Subject: FW: Planning Consultation - Installation of solid fuel appliance @ Dale House, 5, Church Street, Slaidburn App. Ref: 3/2011/0906

Subject: Planning Consultation - Installation of solid fuel appliance @ Dale House, 5, Church Street, Slaidburn App. Ref: 3/2011/0906

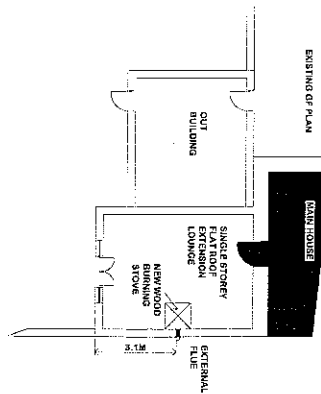
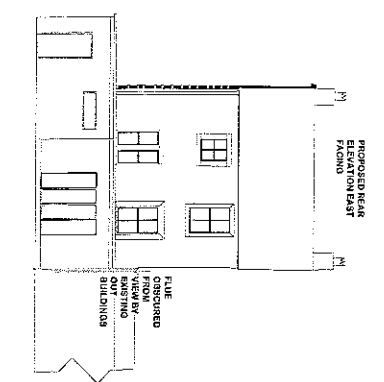
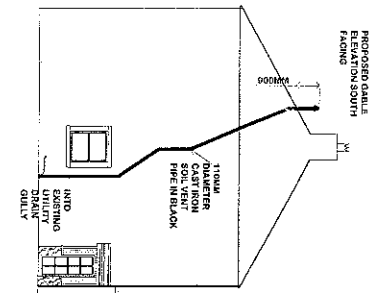
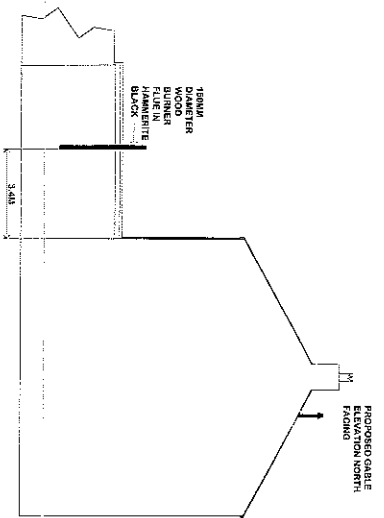
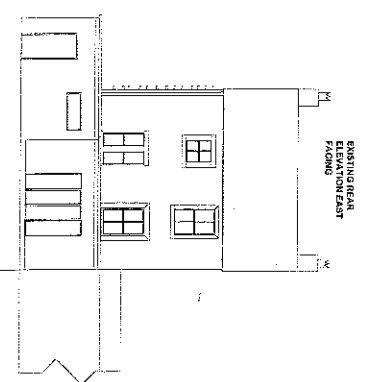
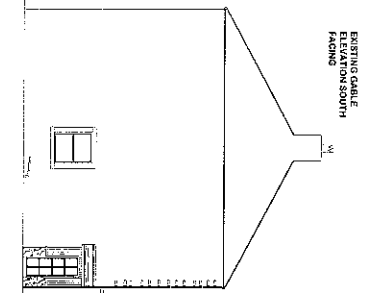
I have very significant reservations with regard to the proposed installation of the wood burning appliance as it depicts a very low level for discharge and dispersal of products of combustion. The low level is highly likely to result in poor dispersal and potential nuisance to both the applicant and neighbours. Furthermore, it is a normal requirement for discharge from any solid fuel appliance to discharge at a minimum of 16 feet to ensure adequate dispersal of products of combustion and ingress of air to prevent fugitive emissions within the room being heated.

Also the position shown on the plans shows discharge at a similar level to 1st floor windows both of the applicant and neighbouring properties with obvious dangers of exposure to products of combustion.

I would ask that the applicant refers to the manufacturers instructions as to installation requirements to confirm the above and/or obtains advice from a HEATAS registered engineer or the Solid Fuel Advisory Service. In addition, the installation of a solid fuel appliance requires Building Regulation approval unless installed by a registered Heatas installer.
